A12 Chelmsford to A120 widening scheme

8.16 Statement of Common Ground with Witham Town Council

February 2023

Statement of Common Ground with Witham Town Council

| Drawing Title: ENVIRONMENTAL STATEMENT MODELLED CHANGE IN NO ₂ BETWEEN THE OPENING YEAR (2027) DO MINIMUM AND DO SOMETHING SCENARIOS FOR HUMAN HEALTH RECEPTORS - SHEET 4 OF 8 | | | | | | |

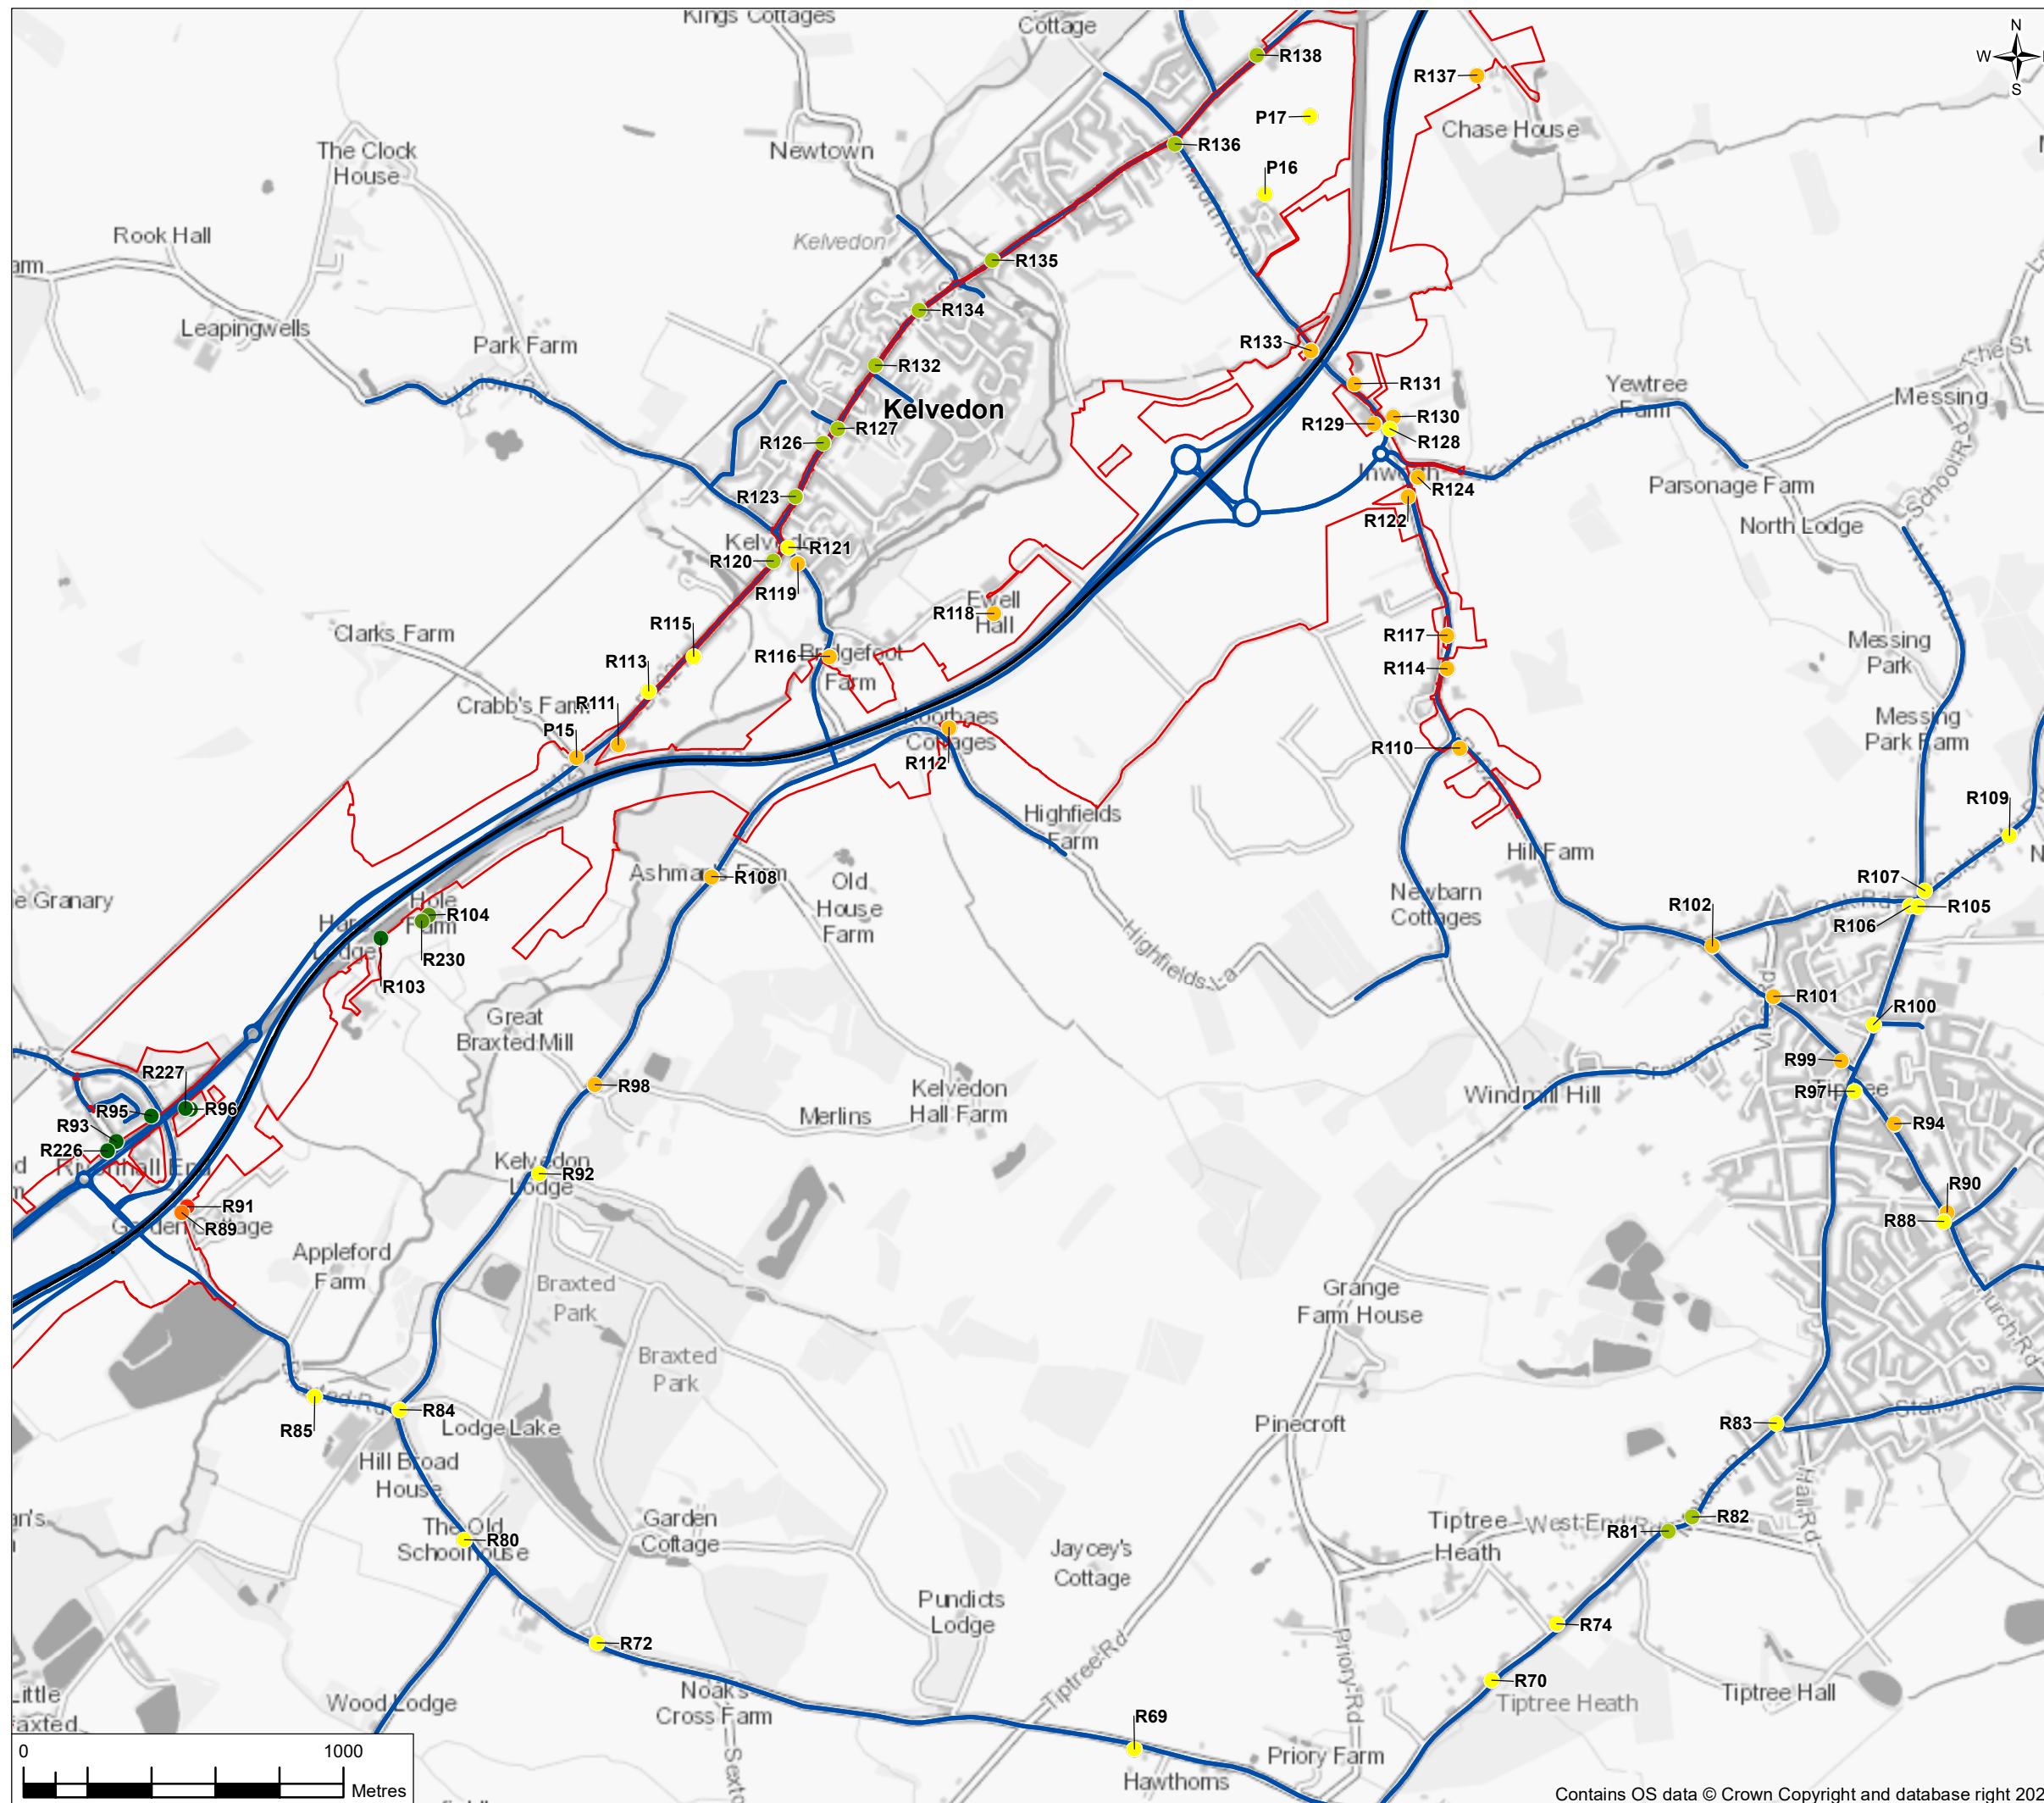
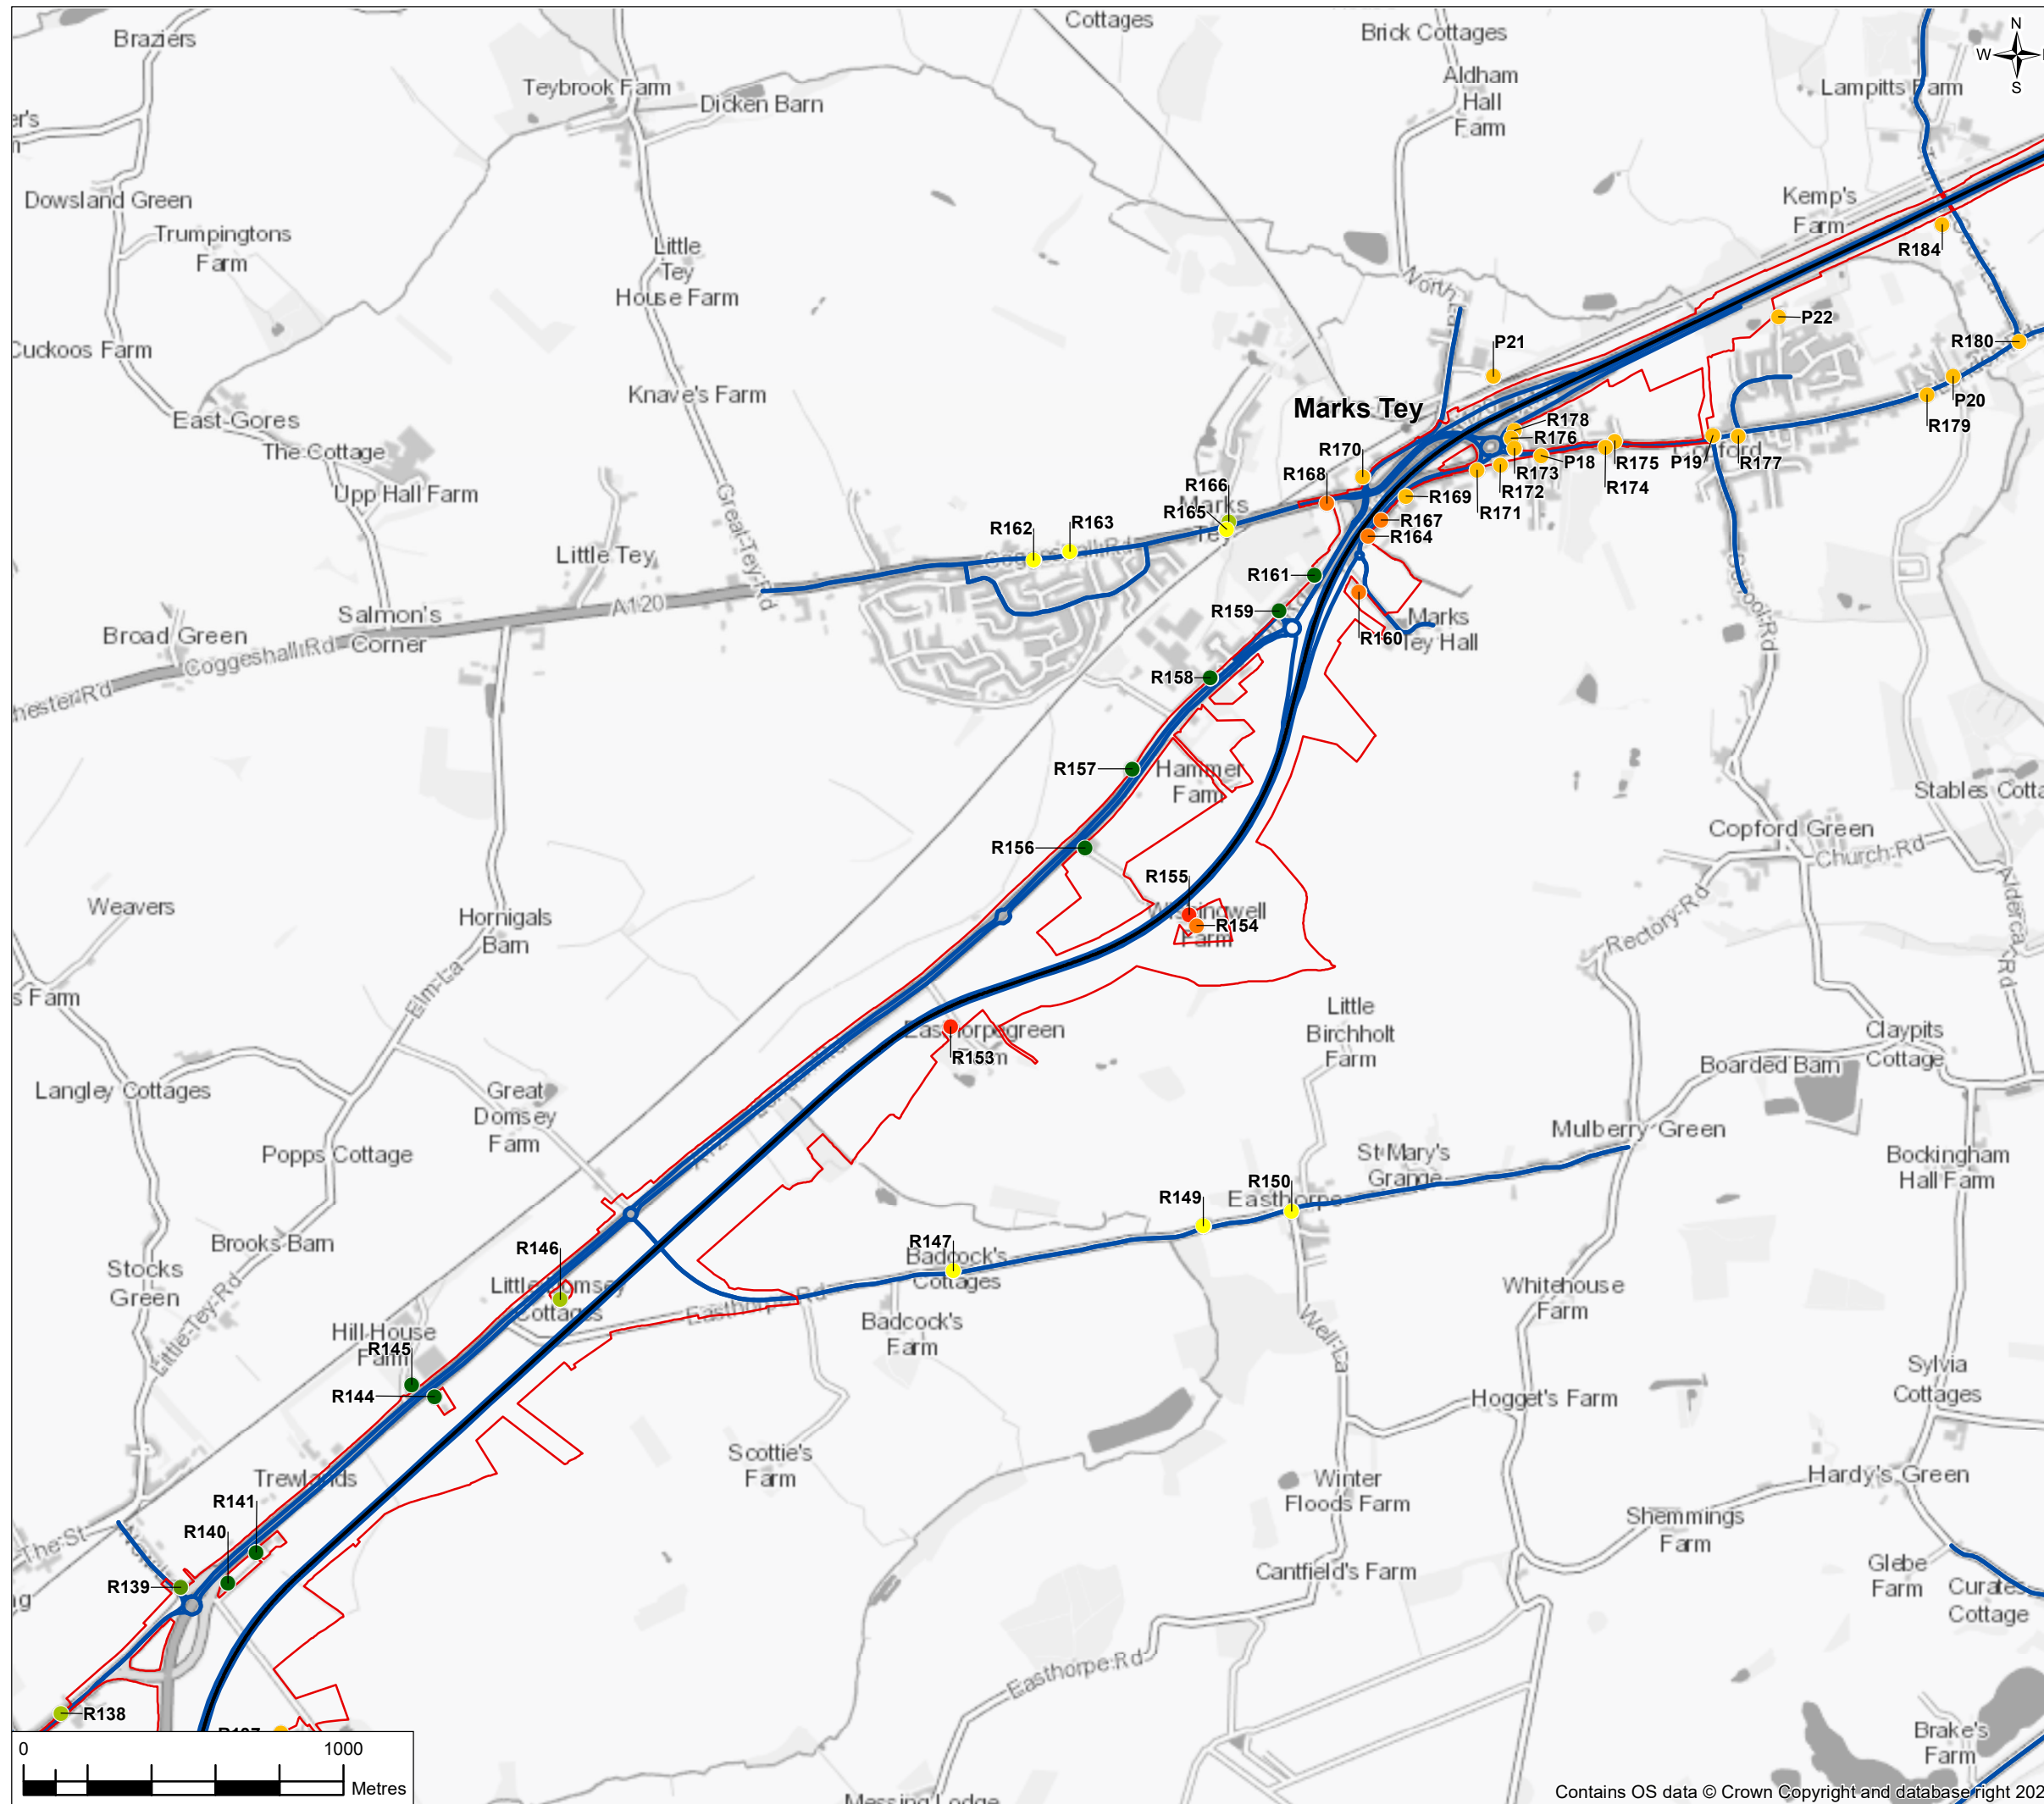
5	Operational noise	Environmental Statement, Chapter 12,	<i>Road noise from operation of A12</i>	Please see response to Relevant Representation, RR-084-005.	In discussion	27/01/2023

Ref	Issue	Doc Reference	Witham Town Council Position	National Highways Position	Status	Date
		Noise and vibration [APP-079] Environmental Statement, Figure 12.8 Noise Change Contour Map Sheets 4 and 5 [APP-235]		The extent of enhanced low noise surfacing goes from east of junction 21 past junction 22, ensuring the benefits of the enhanced low noise surfacing to the community of Witham.		
6	Construction noise		<i>Noise during the construction period.</i>	National Highways continues to investigate the construction methodology for the retaining walls on the north side of the A12 by Market Lane. National Highways will, if practicable, aim to maintain the existing noise barrier during the construction works.	In discussion	27/01/2023
7	Loss of mature Trees and Shrubs	Environmental Statement, Chapter 9, Biodiversity [APP-076] Retained and Removed	<i>Loss of mature trees and shrubs</i>	Please see response to Relevant Representation, RR-084-006. The Applicant acknowledges that construction of the proposed scheme would result in adverse impacts to Whetmead Local Nature Reserve and Local Wildlife Site through the permanent loss of	In discussion	27/01/2023
